Application Ref: H09-0796-25

Proposal: **Proposed Erection of 2 Bungalows**

Location: **Land East of Forest Way, Holbeach, Spalding, Lincolnshire**

ADDITIONAL INFORMATION REQUIRED

PROPOSED SITE PLAN
scale 1:200

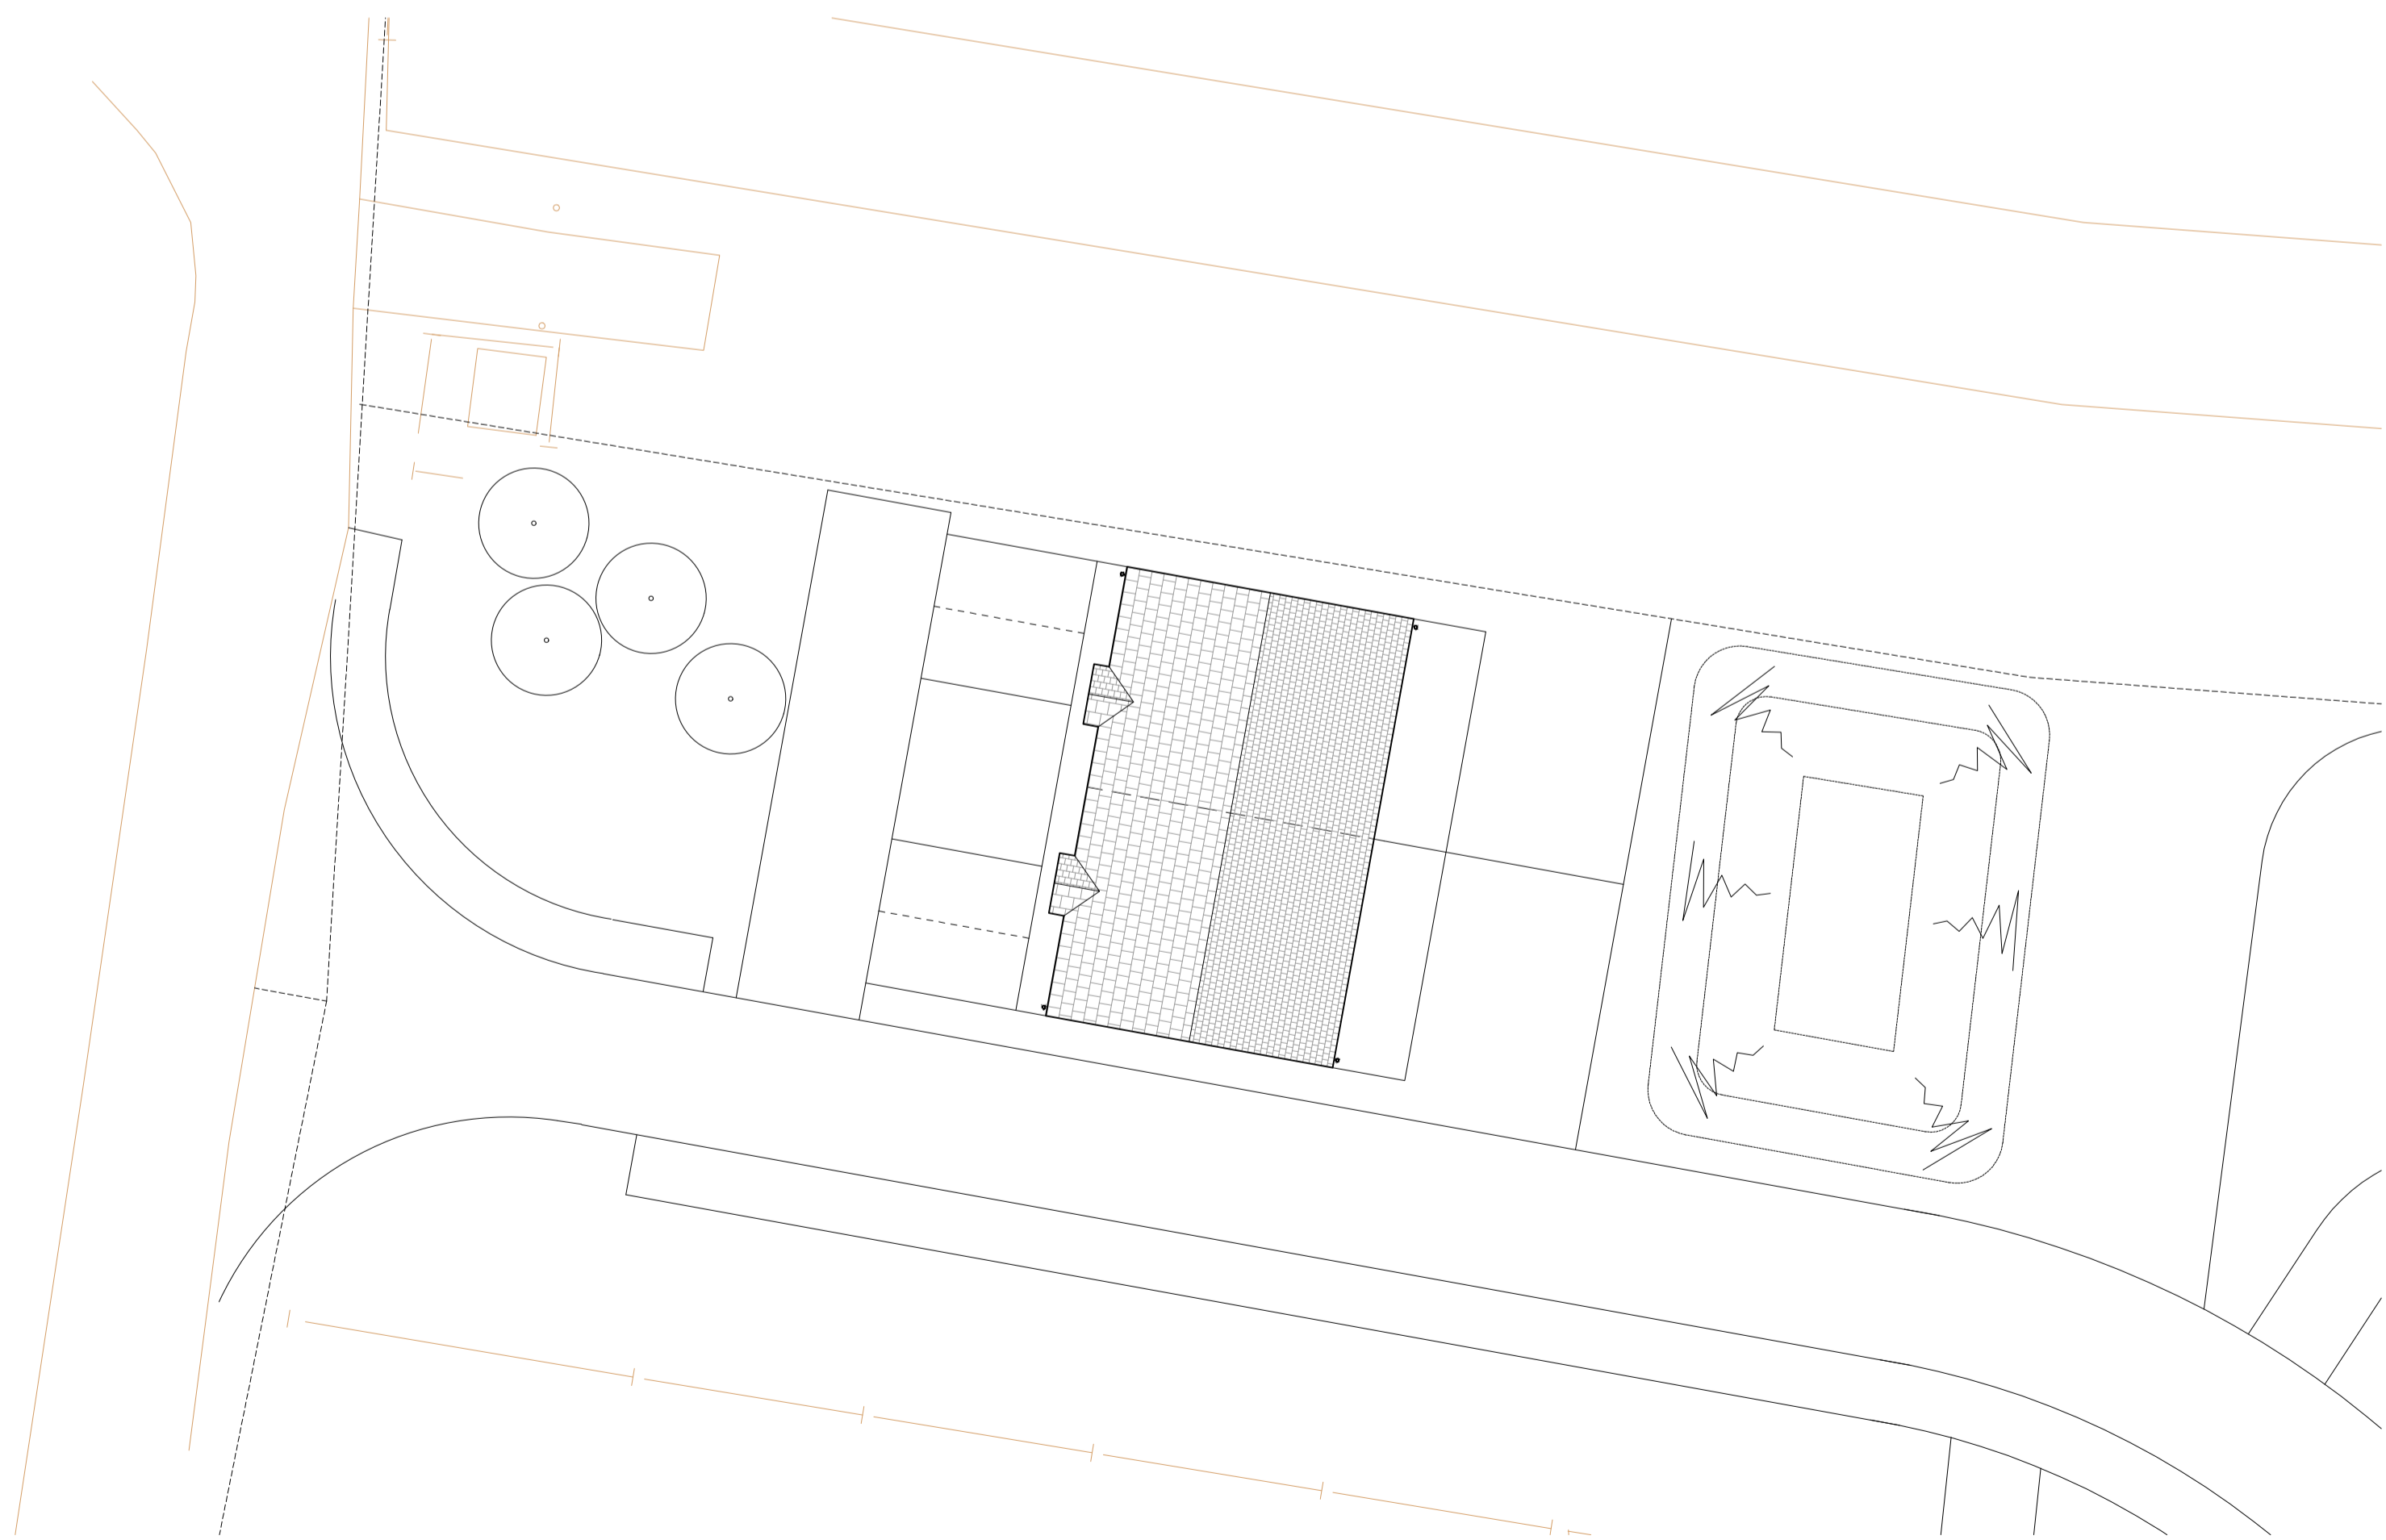
The dimensions of the private drive and parking spaces are to be detailed.

The proposed dwellings are very close to the attenuation basin - how will the increase in permeable area affect the functionality of the basin? This should be taken into account by the LPA when they assess the drainage/surface water flood risk.
